Our ref: SSD 5169 MOD2, 12/03480

**Horsley Drive Business Park Subdivision and Infrastructure Works (SSD 5169) – MOD2  
Response to Submissions**

**HORSLEY DRIVE BUSINESS PARK – SSD 5169 MO1– REQUEST FOR MODIFICATION**

DRAWING TITLE:
ROUNDBABOUT TURNING PATHS
PLAN
Drawing No: Co114.92.05-SK02
Scale: A

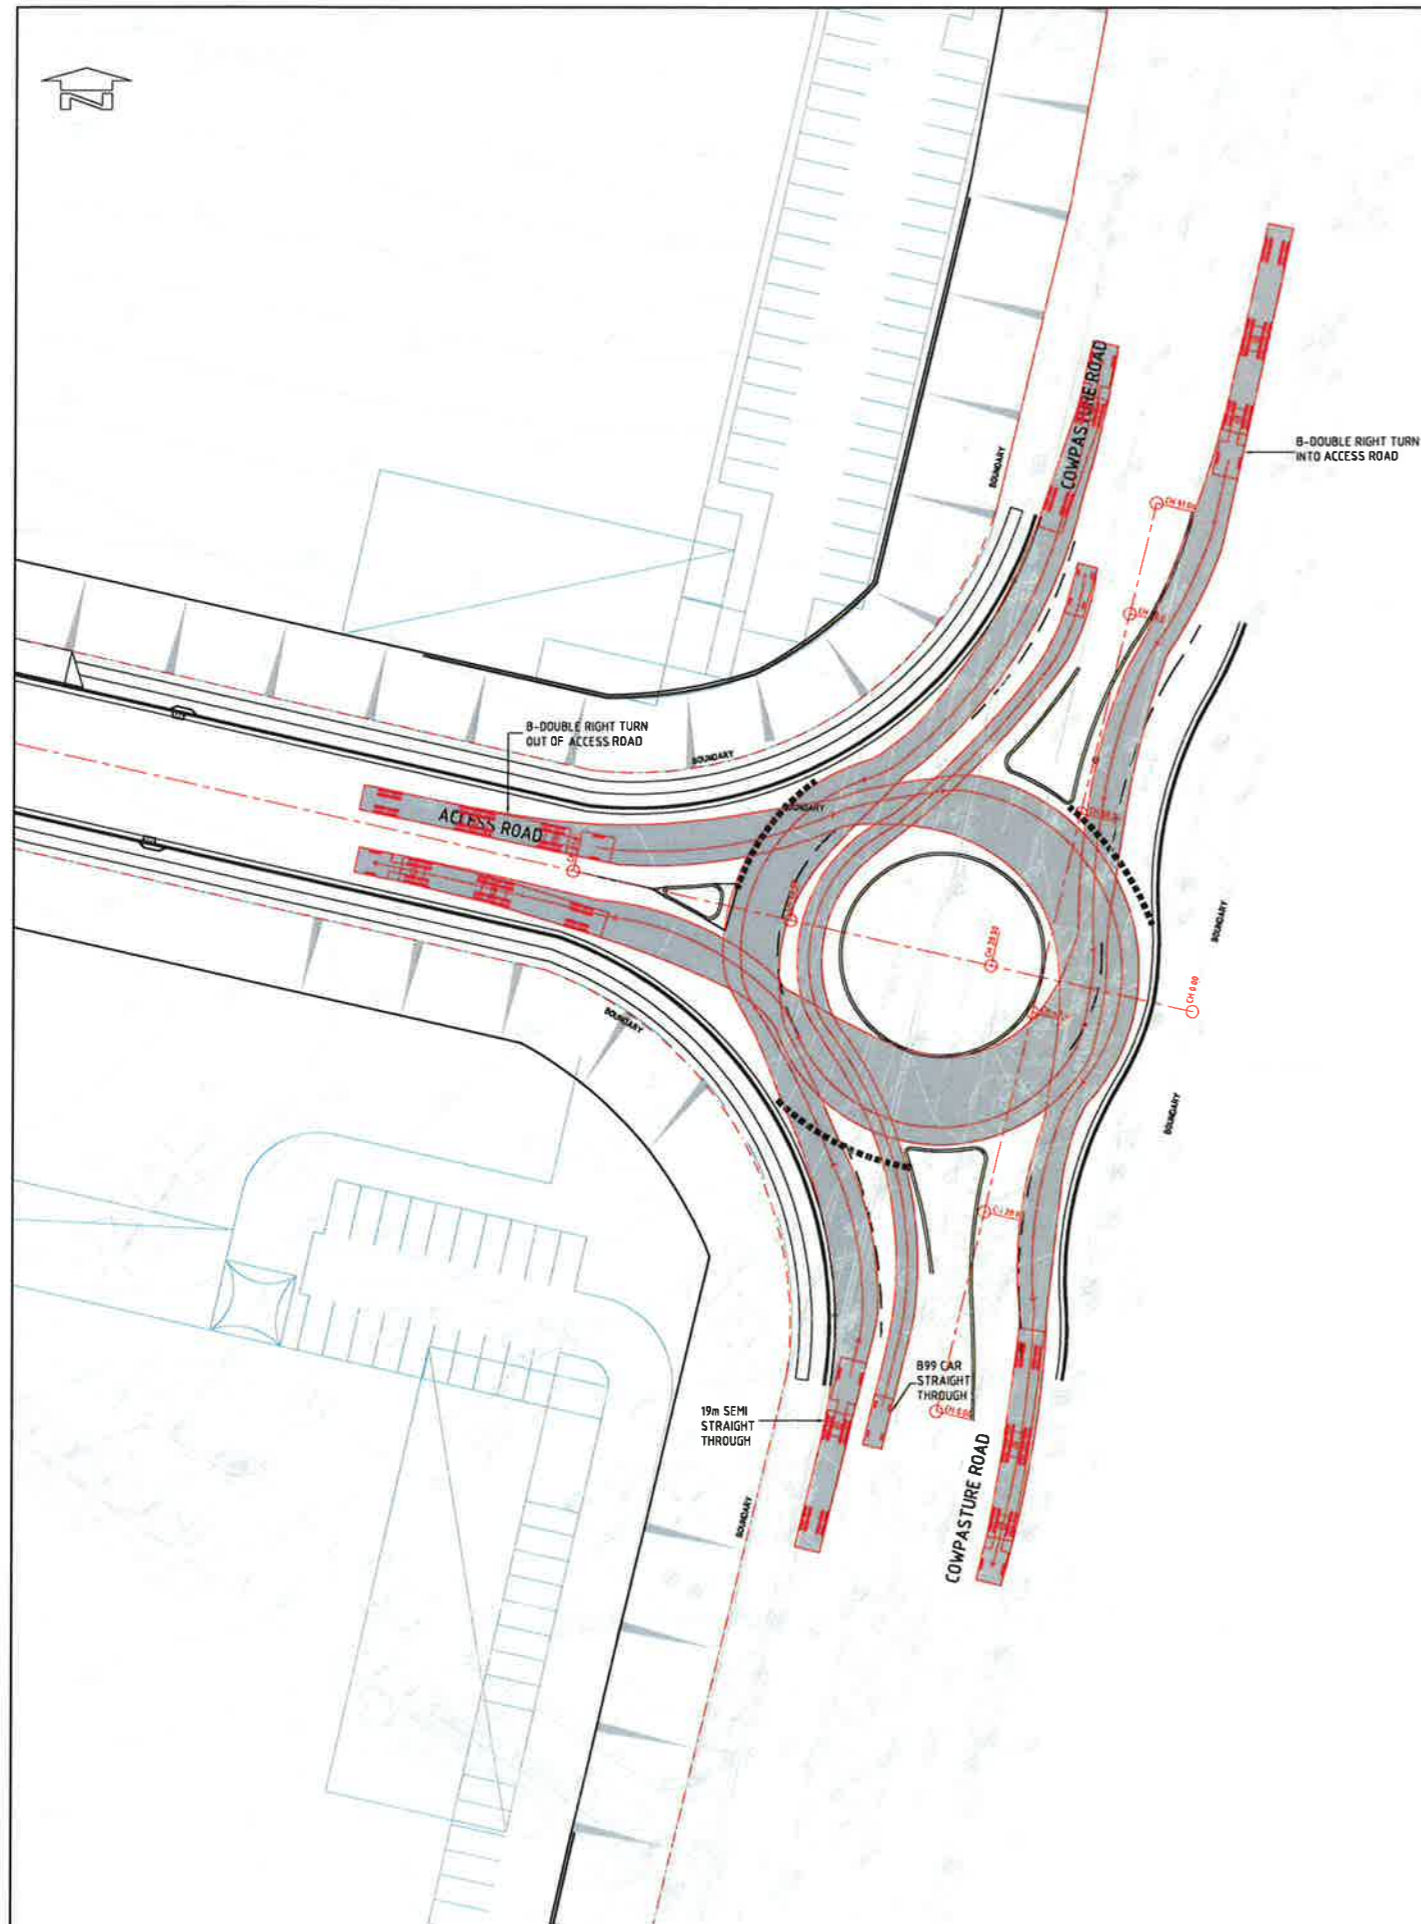
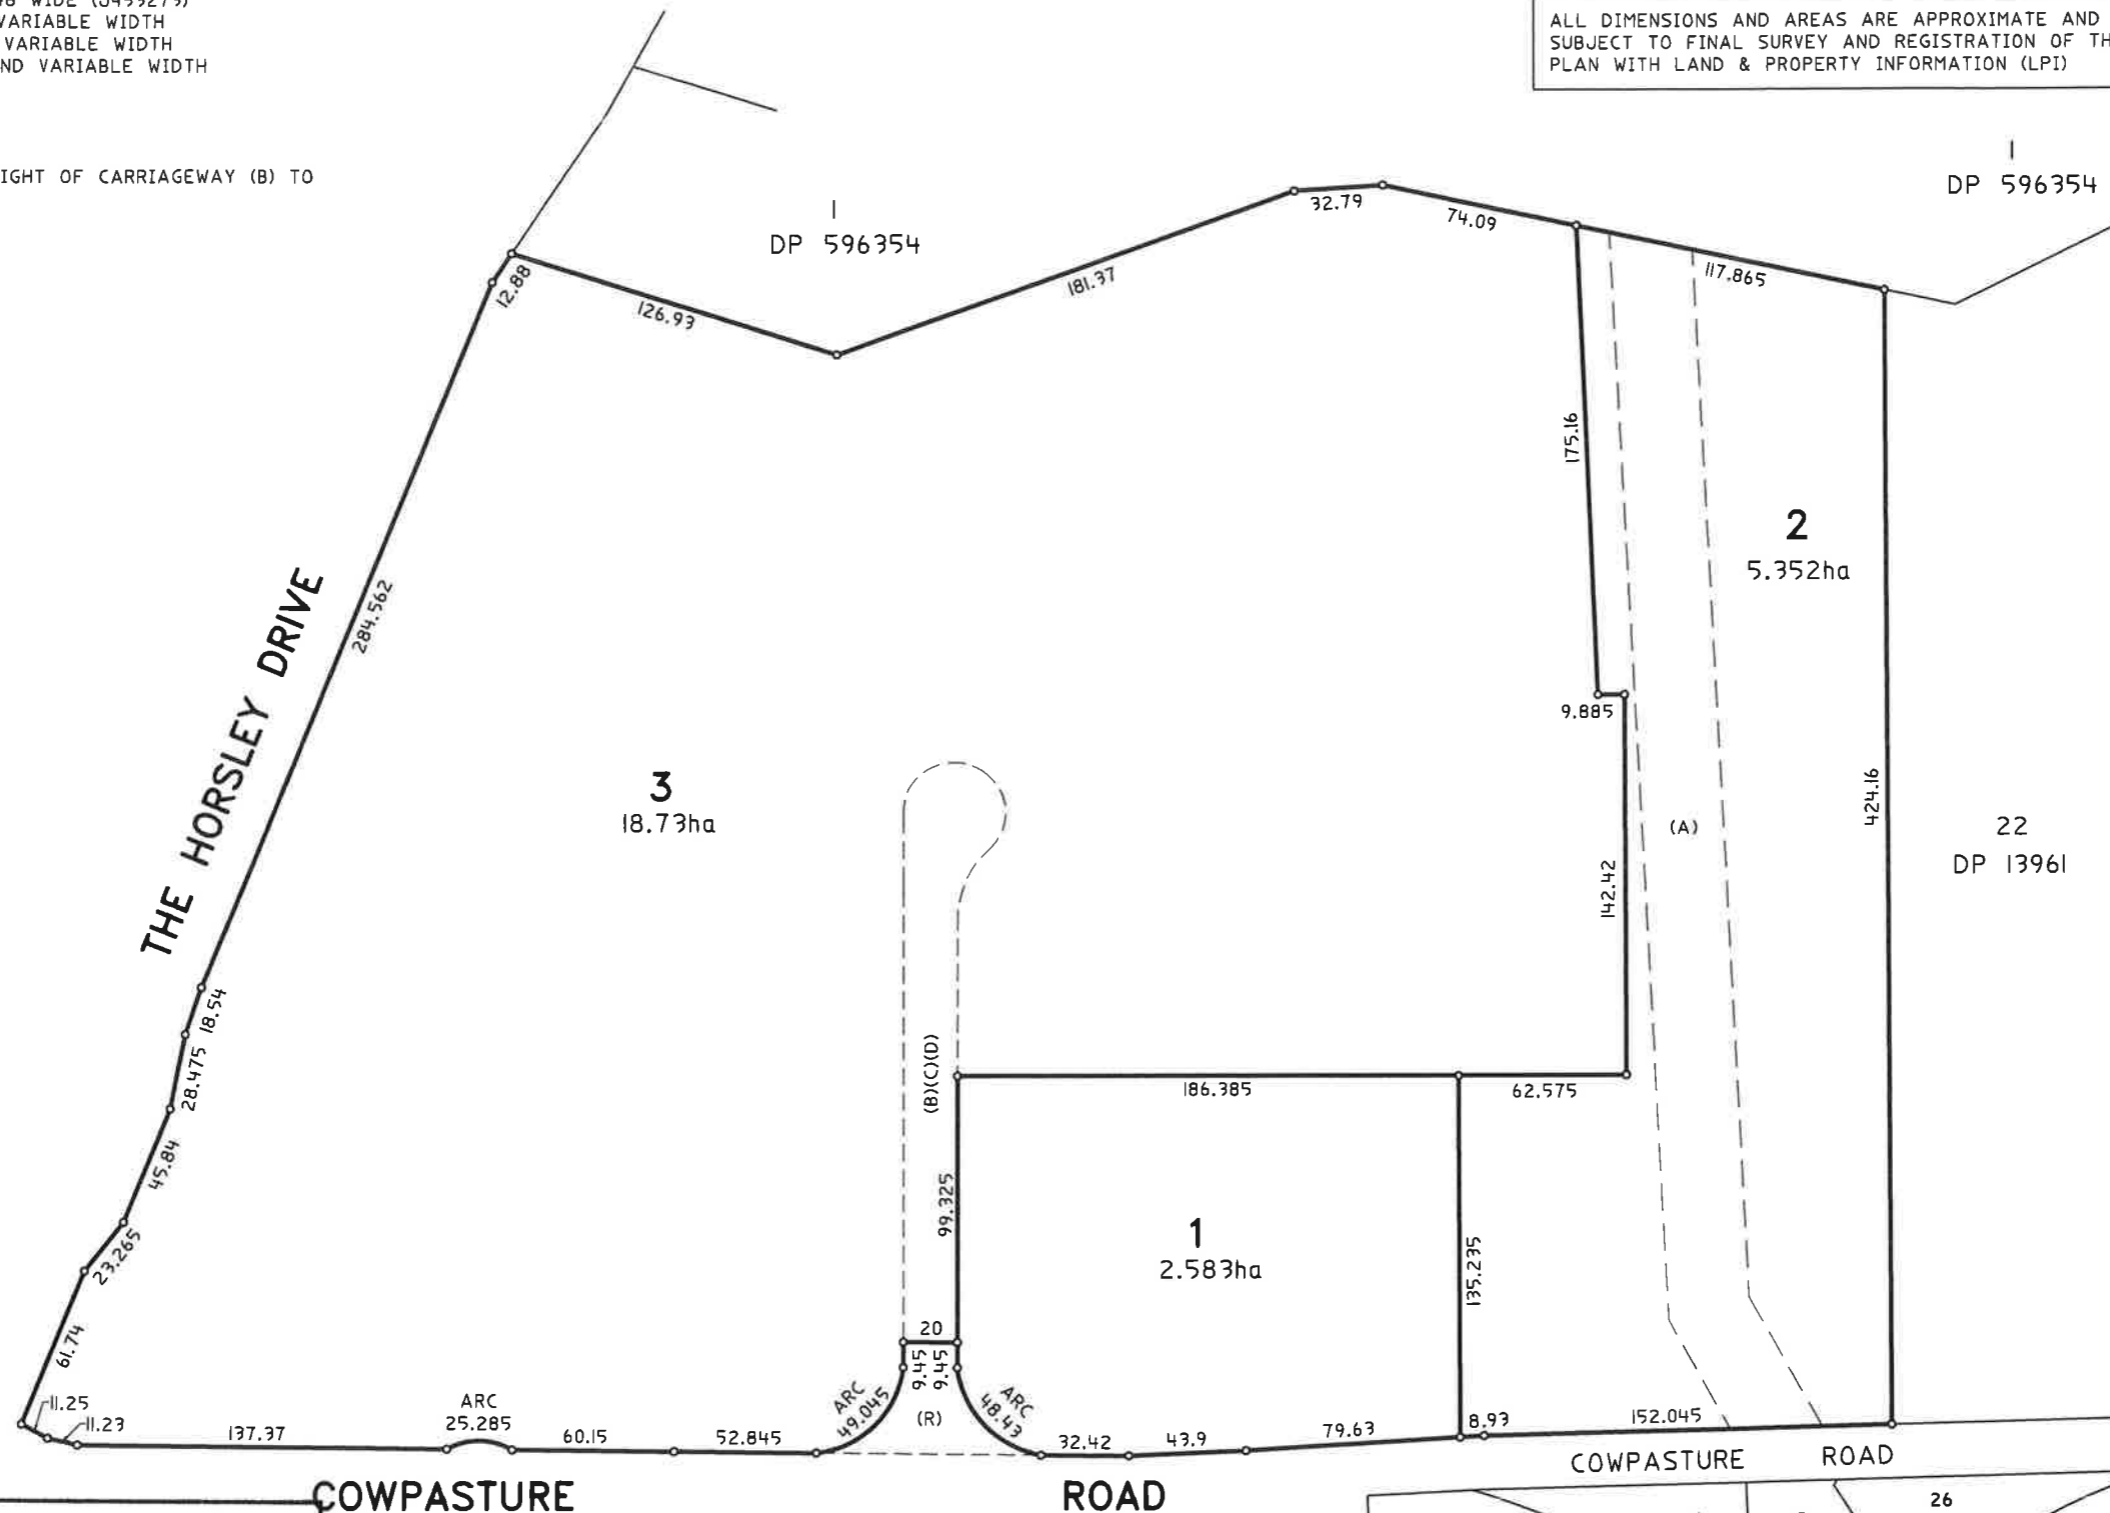
- Design of the proposed roundabout shall comply with Austroads Guide to Road Design Part 4B, Austroads Guide to Road Design Part 4, Austroads Guide to Road Design Part 4A and Austroads Guide to Traffic Management Part 6. The installation of the roundabout requires approval under Section 138 of Roads Act 1993. A dimensioned plan of the roundabout shall be submitted to the Council and the plan will require approval from Fairfield Traffic Committee.

- Turning path templates for B- Double vehicle shall be used to justify circulation within the proposed roundabout and entering/exiting from The Horsley Drive Business Park are satisfactory. These swept path diagrams shall be submitted to the council for assessment.

CONCEPT MASTERPLAN  
1:1000 @ A1

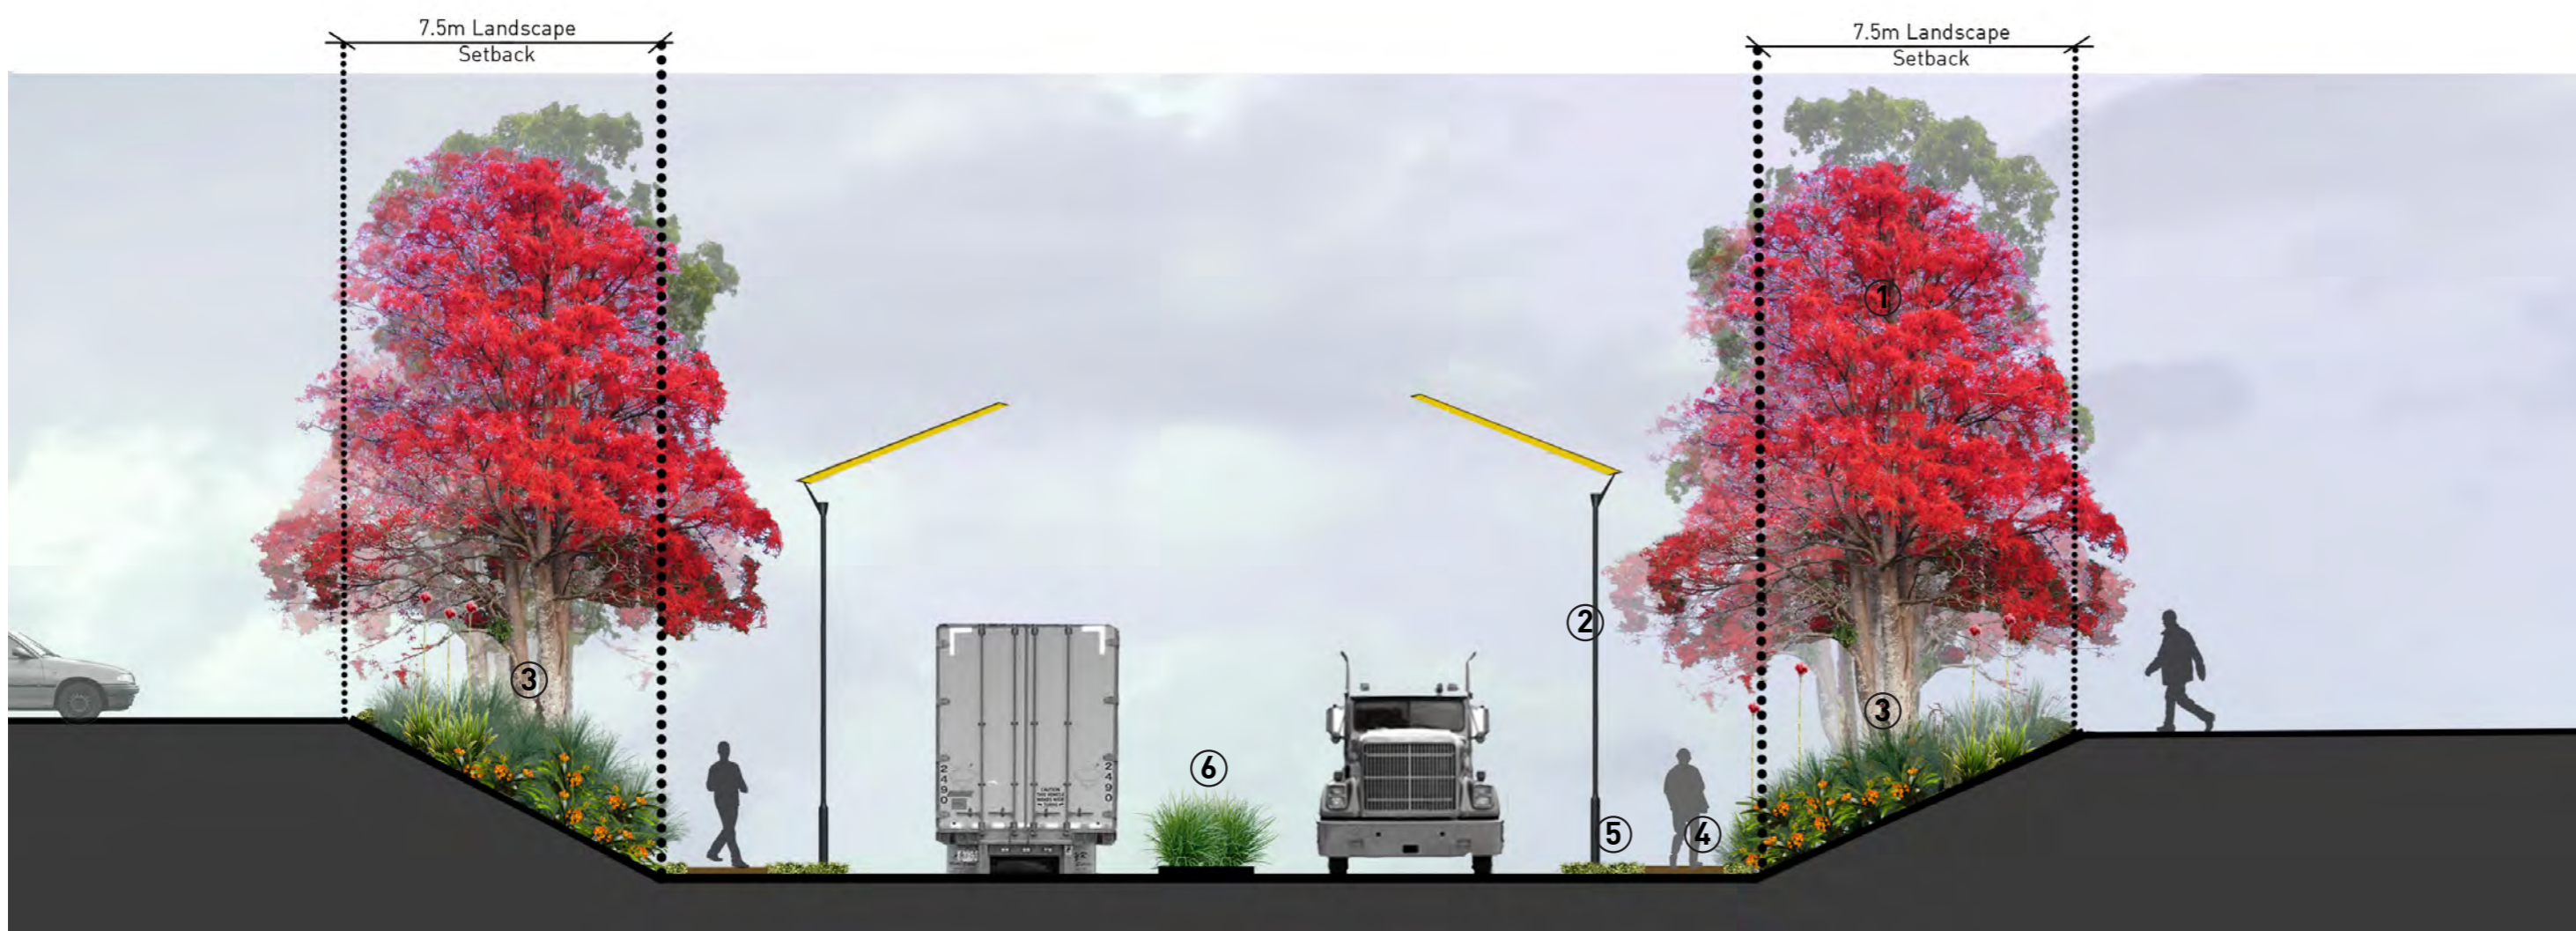
**2. Deletion of the Warehouse and Office Footprints/Envelopes from the Master Plan (MP WSPT FS-011)**

The development consent did not provide for the approval of any footprints or concept envelopes for the site. The inclusion of building footprints on the Master Plan as part of the proposed modification may result in a substantially different development to what was originally considered and approved. The inclusion of the footprints also pre-empts the assessment of the final built form for the site which should be the subject of individual development applications to the Council.

Accordingly, it is requested that you delete all reference to the warehouse and office envelopes on the proposed Master Plan.
